MODIFICATION REQUEST:

61 Mobbs Lane, Epping (Former Channel 7 Site)

Internal reconfiguration and minor design changes to Buildings 7 and 8 (MP 10_0158 MOD 2)

Director-General's
Environmental Assessment Report
Section 75W of the
Environmental Planning and Assessment Act 1979

Title Building 7 Ground Floor Plan

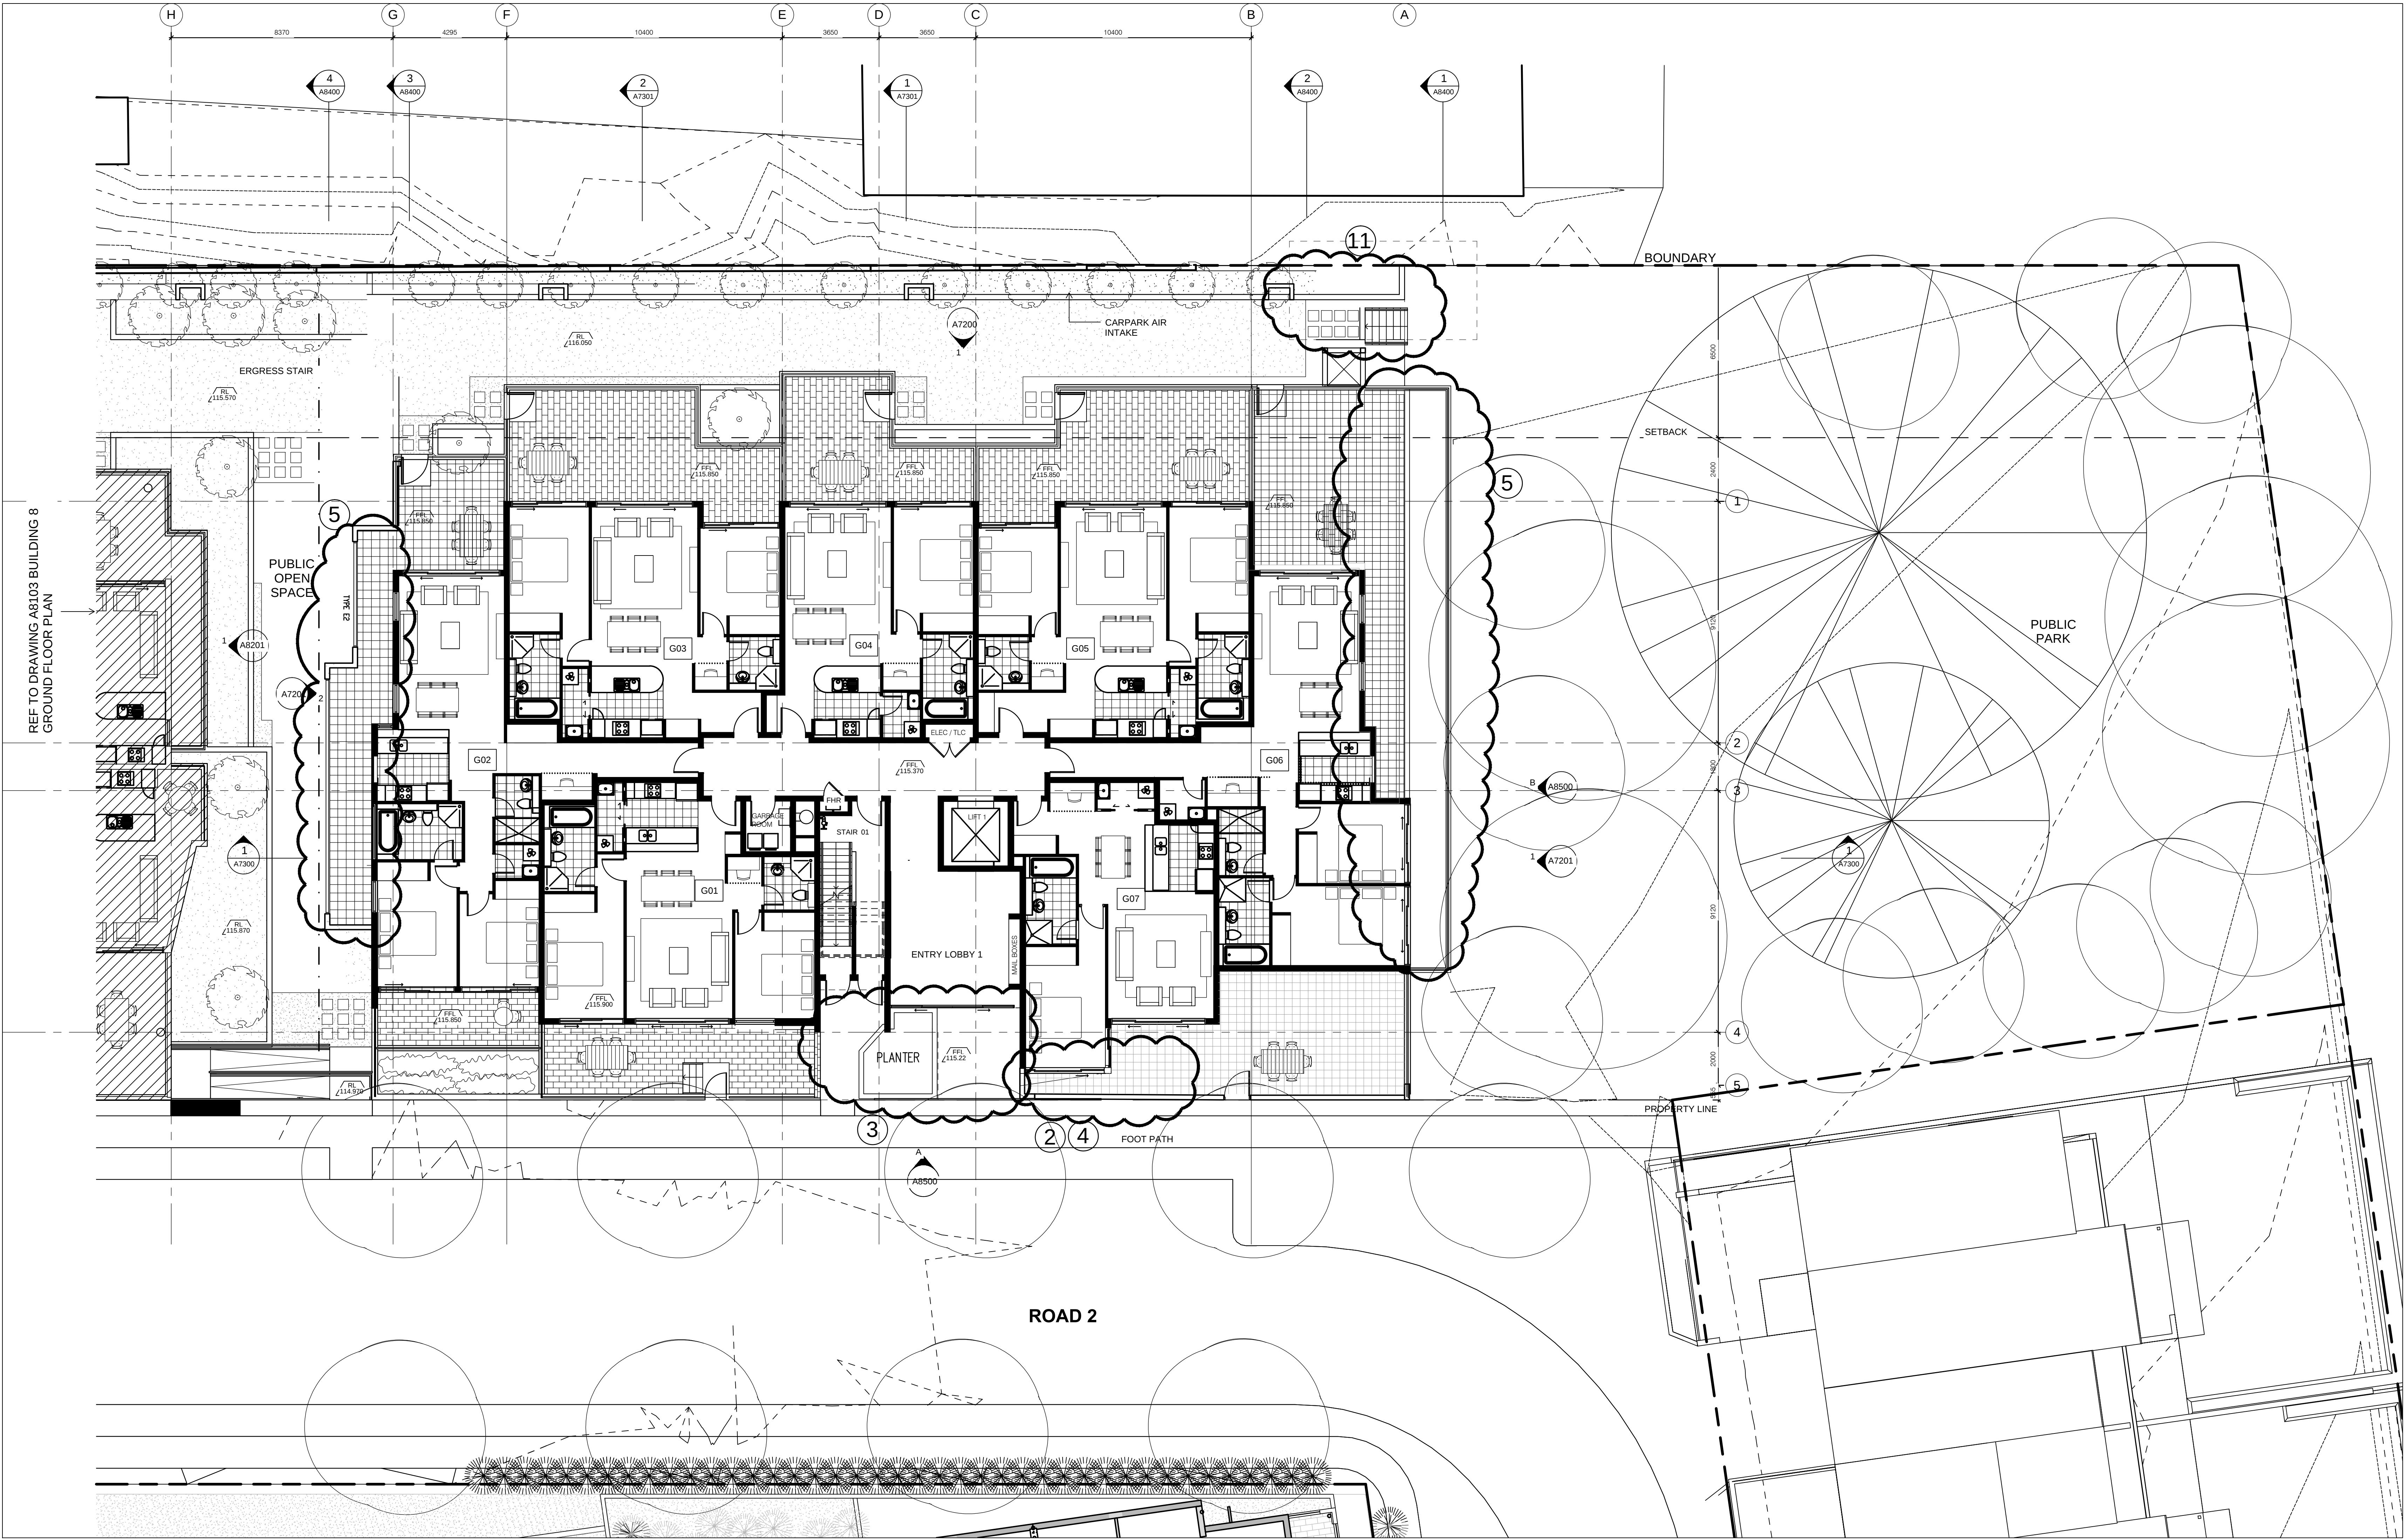
The Council advised that it is concerned that creating a courtyard along the western boundary of apartment G02 in building 7, and the extension of the courtyards on the eastern boundary of apartments G10 and G11 of building 8 would result in a reduction in the public open space identified in the Concept Plan.

The creation of a new courtyard along the western elevation of apartment G02 in building 7, and the extension of the courtyards along the eastern boundary of apartments G10 and G11 in building B8 would result in a non-compliance with the requirements of the *Parramatta Development Control Plan 2005* (PDCP) and the department's *Residential Flat Design Code*, as the setback between these courtyards will be reduced from 6 m to approximately 3 m (see **Figures 4 and 5** below).

The department does not support this change on the basis that it would result in a poor outcome for the future occupants of these apartments. As such, the department has included conditions in the Instrument of Modification to clarify that this component of the application is not approved.

Note: The extension of the balconies adjacent to Apartments G02, 010 and 011 are not approved as part of this application.
